## ***Rezoning Petition Review***

**Date of Review:** October 29, 2020 (***Revised November 30, 2020***)

**Rezoning Petition #:** 20-133

**Location of Property:** Approximately 26.20 acres located on the south side of Hamilton Rd, east of Youngblood Rd and west of Steele Creek Rd.

Conceptual Site Plan

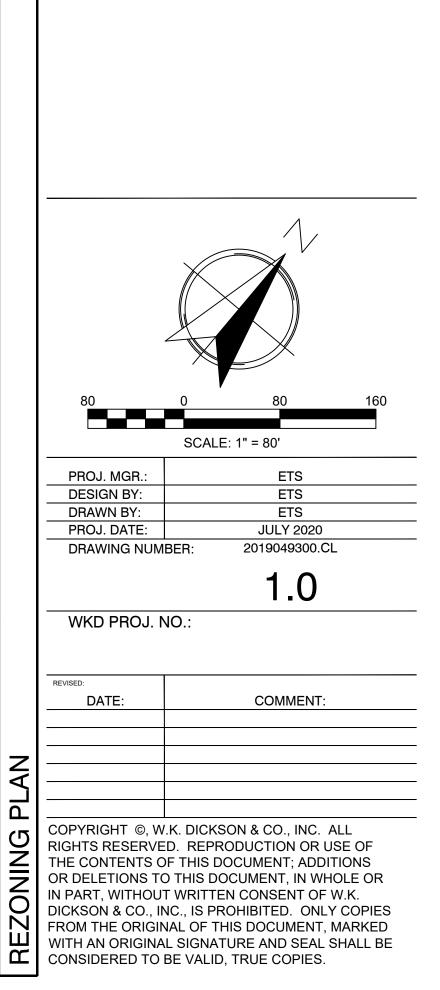
**Concerning Storm Water:** Please include the following note under Environmental Features. *For adjoining parcels receiving storm water discharge the petitioner shall analyze the adequacy of the existing storm water conveyance on the adjoining parcels to and including the nearest public R/W. If the existing storm water conveyance on the adjoining parcels is found to be inadequate, the Petitioner shall make a good faith effort with the property owner(s) to improve the storm water conveyance or mitigate the storm water discharge onto the adjoining parcels.*
